Tween Bridge Solar Farm

9.4 Statement of Common Ground with the Environment Agency

Deadline 6 - September 2026

Document Reference: 9.4

### Non-Intrusive Cable Crossing – Watercourse/IDB Drain/Main River/Canal

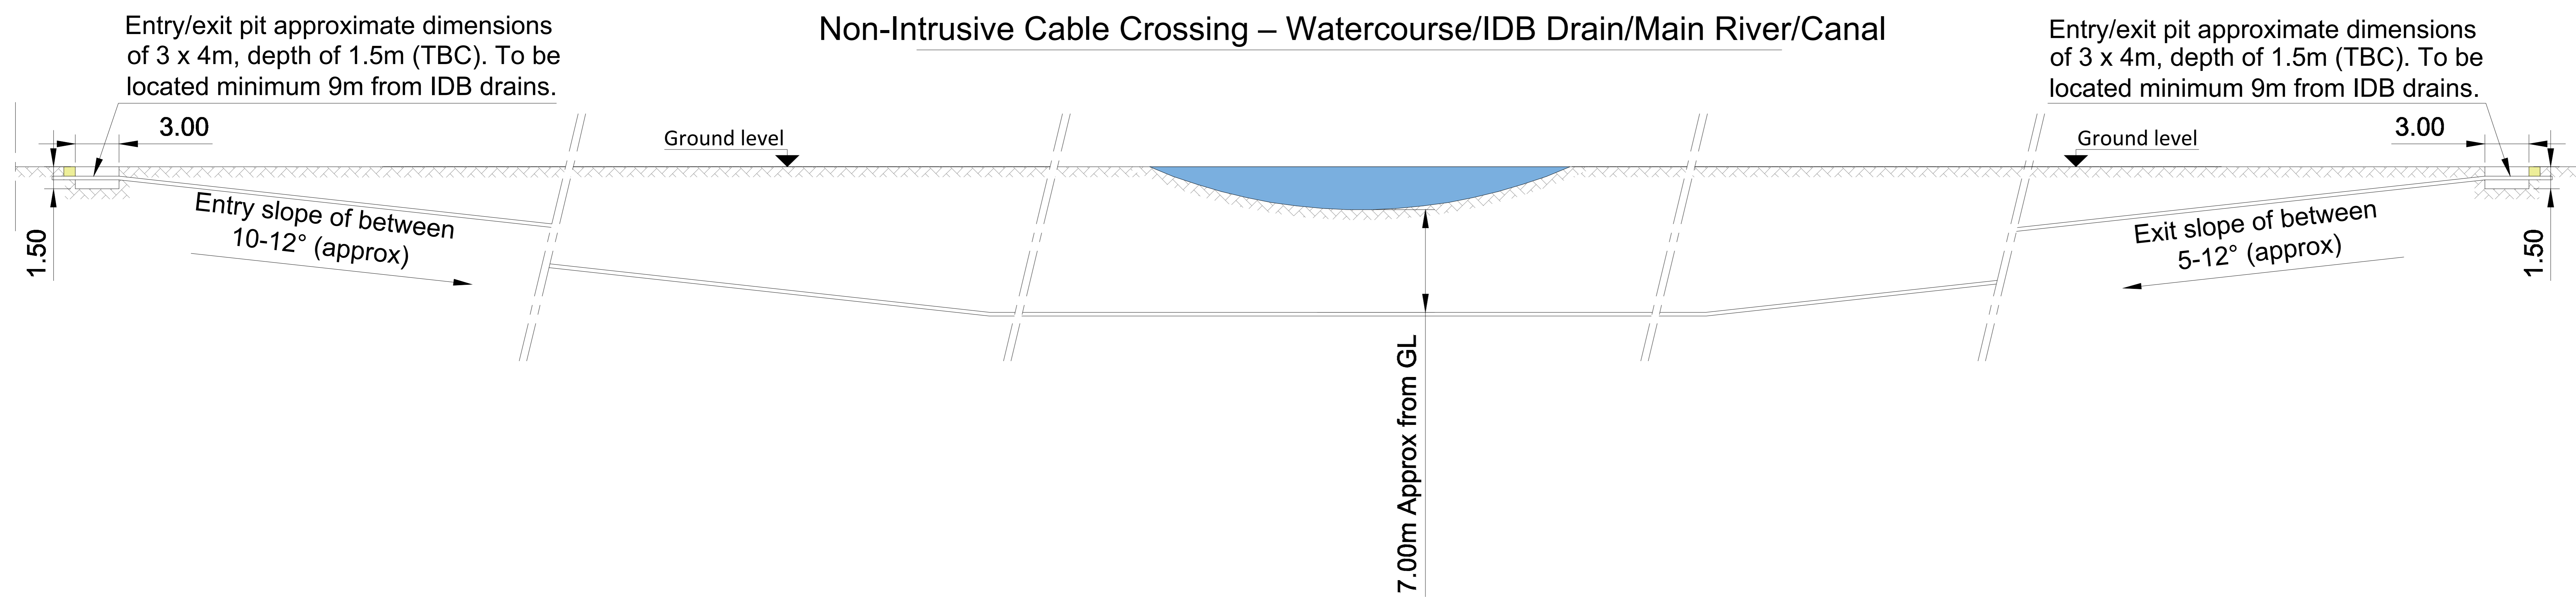
other suitable alternative locations – sequential approach must be applied. - Any cables crossings under Main Rivers are required to be directionally drilled. - Requirement to compensated for any displacement of flood waters.
August 2023	Email Consultation	Updated Tidal Trent model data requested from the EA following advice that more recent flood model data covering the site was available.
October 2023	Email Consultation	Non-statutory consultation request from the Applicant sent to the EA. Scheme and Online Webinar details provided to the EA.
November 2023	Email Consultation	Non-statutory consultation comments received from the EA. The EA requested flood mitigation measures to be detailed in metres above Ordnance Datum and that mitigation beyond 1m of raising would be required, both of which have since been actioned. The EA flag the need to assess residual flood risk in the context of the Isle of Axholme Critical Flood Level. The EA noted they do not consider use of bunds as flood defences on site to be appropriate. The requirement for a sequential approach was raised by the EA, noting they would prefer Flood Zone 3b to remain undeveloped. The EA stated cable crossings below Main Rivers need to be directionally drilled. The EA noted they were satisfied with the proposals to date with regards to water resources and water quality. Information was also provided on biodiversity matters, the need for a Water Framework Directive (WFD) assessment, potential for electromagnetic impacts on fish from cables crossing under watercourses, land contamination and groundwater protection, waste management, historic landfill sites and battery energy storage systems.
